Eastern Creek Business Hub (SSD 5175 Mod 4 and SSD 8588 MOD 2)
Request for Additional Information

I refer to the assessment of SSD 5175 MOD 4 (new roundabout and stormwater changes) and SSD 8588 MOD 2 (Lot 2 layout changes).

DA38 P 1

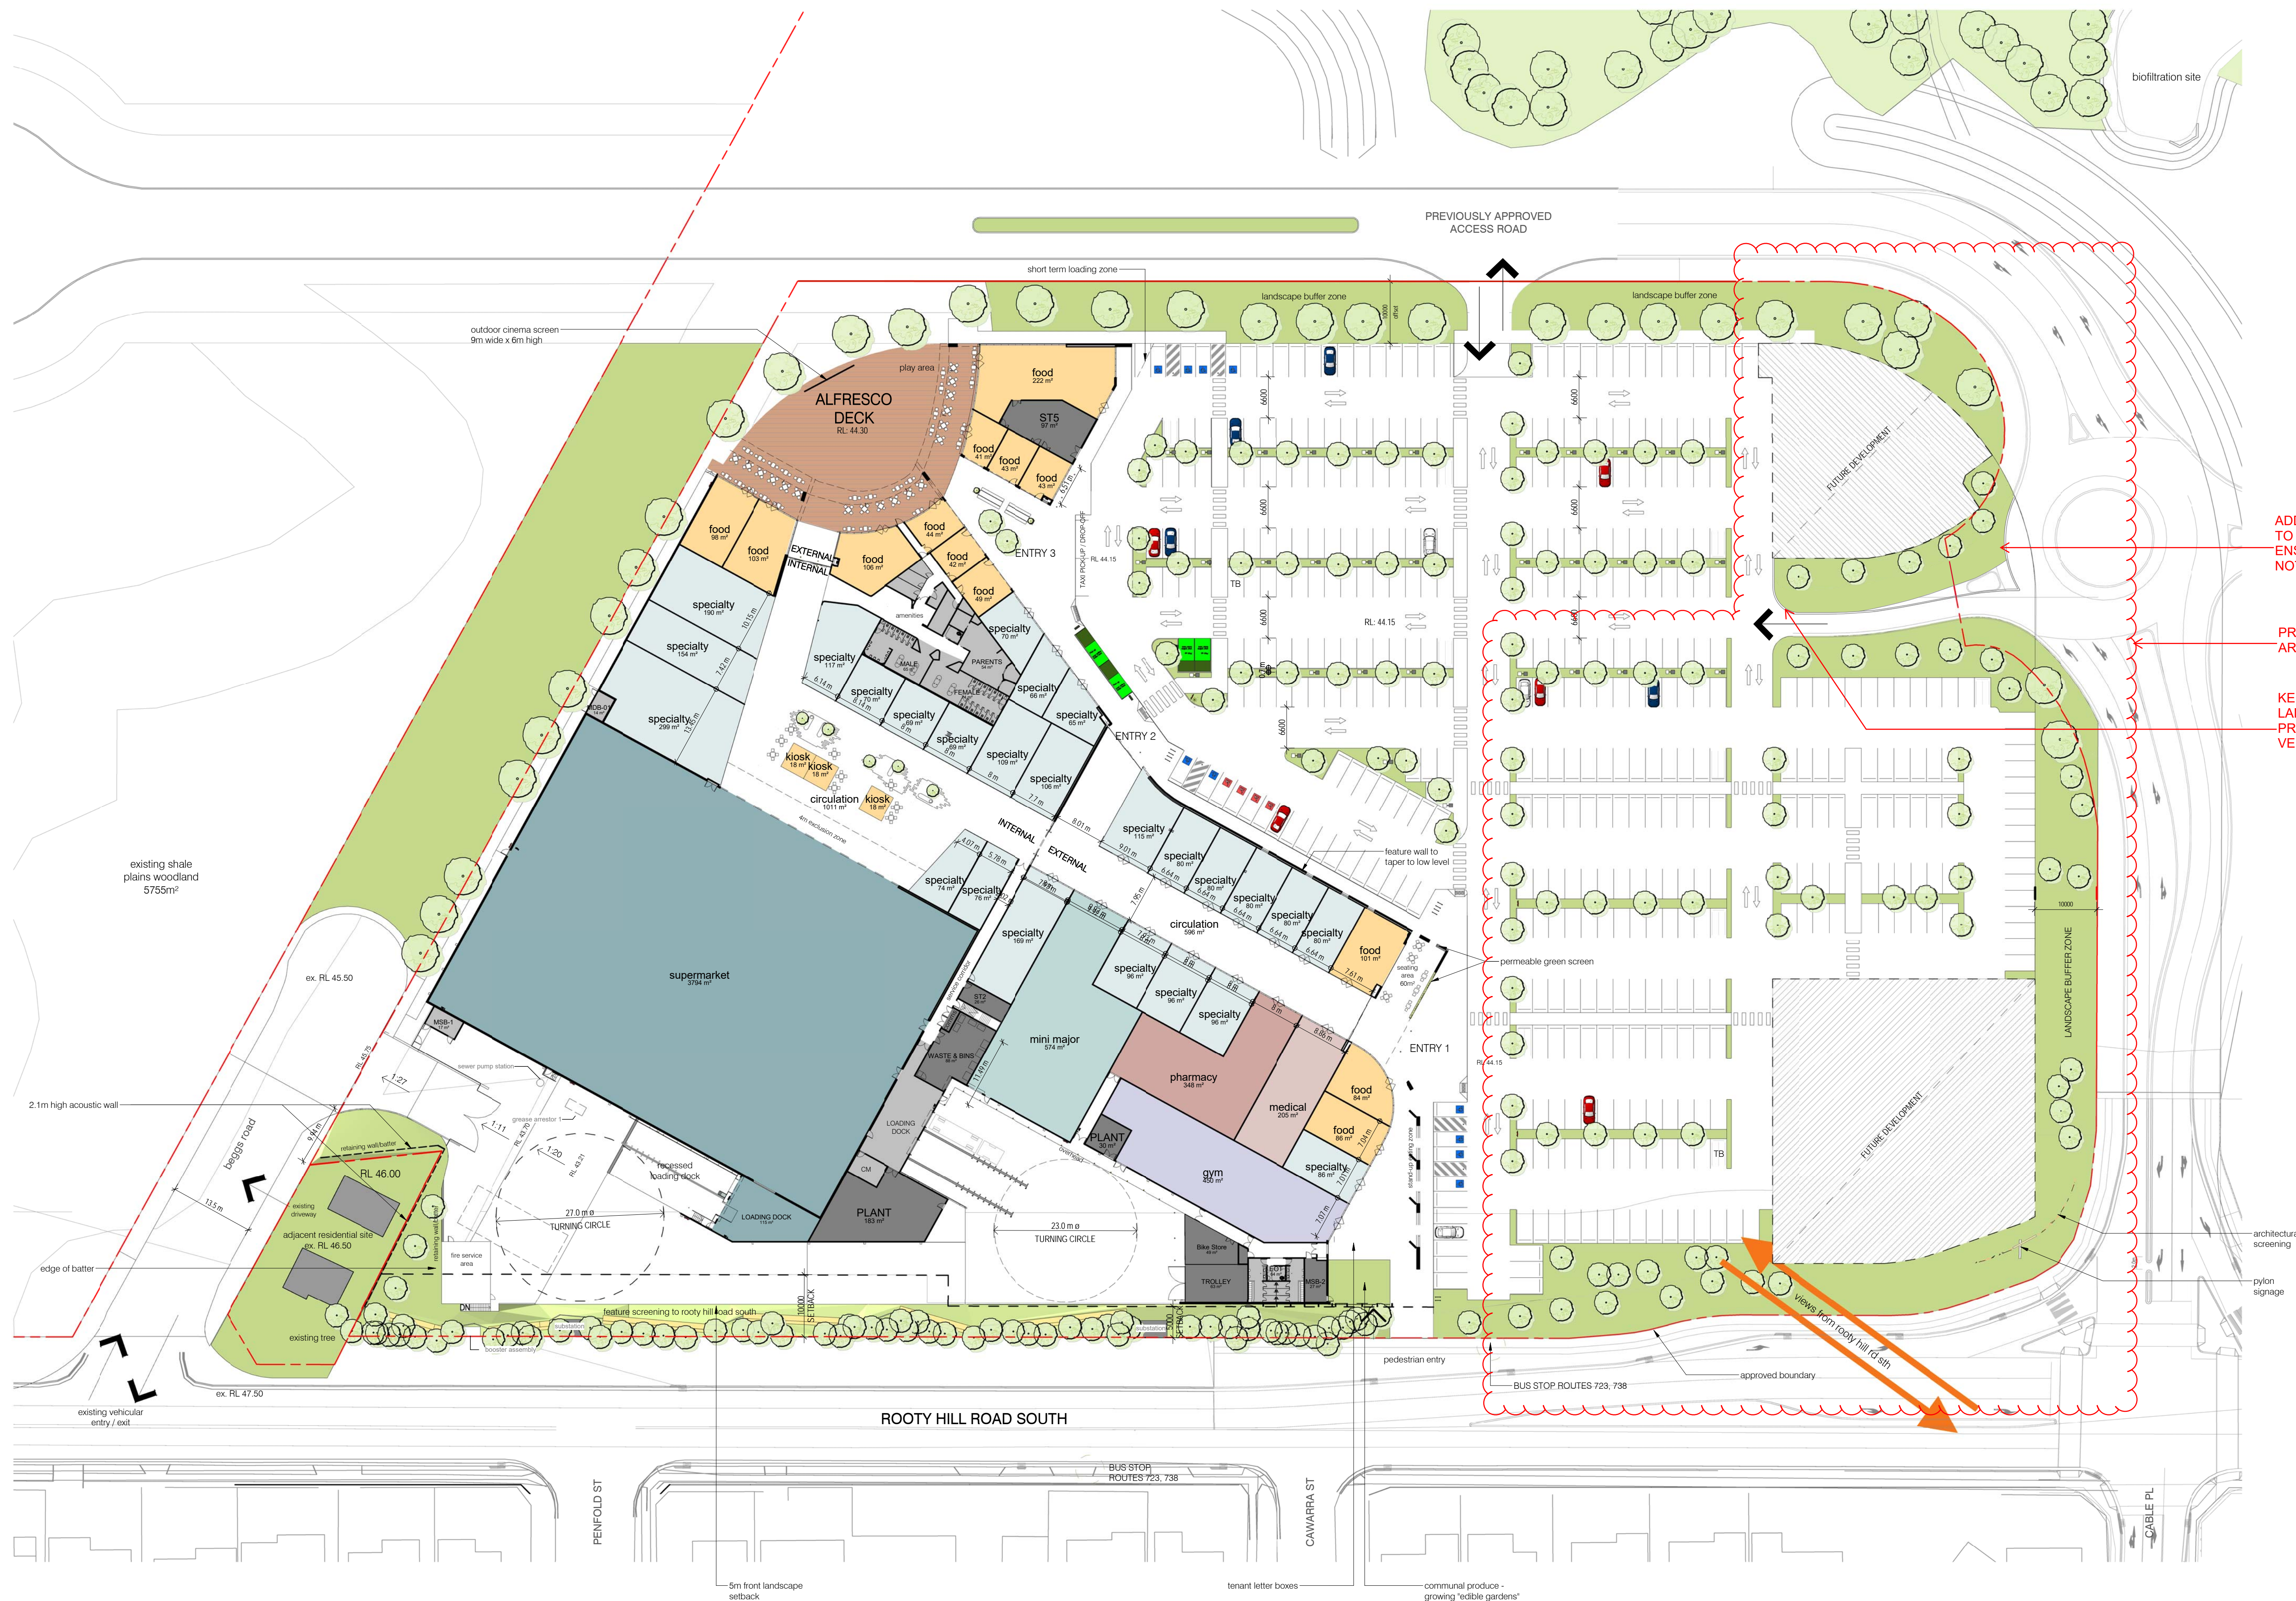
The Department has received a response from Roads and Maritime Services (RMS) in response to the additional information provided (attached). RMS note the proposed roundabout may impact on the functioning of the Rooty Hill Road South / Cable Place intersection. To address this, RMS request access to Lot 2 from the proposed roundabout be modified from an entry/ exit access to an exit only access arrangement.

The Department requests amended concept plans (SSD 5175) and amended detail design plans (SSD 8588) be submitted reflecting the above. This should also be accompanied by an updated traffic statement addressing the suitability of the revised access arrangements into Lot 2.
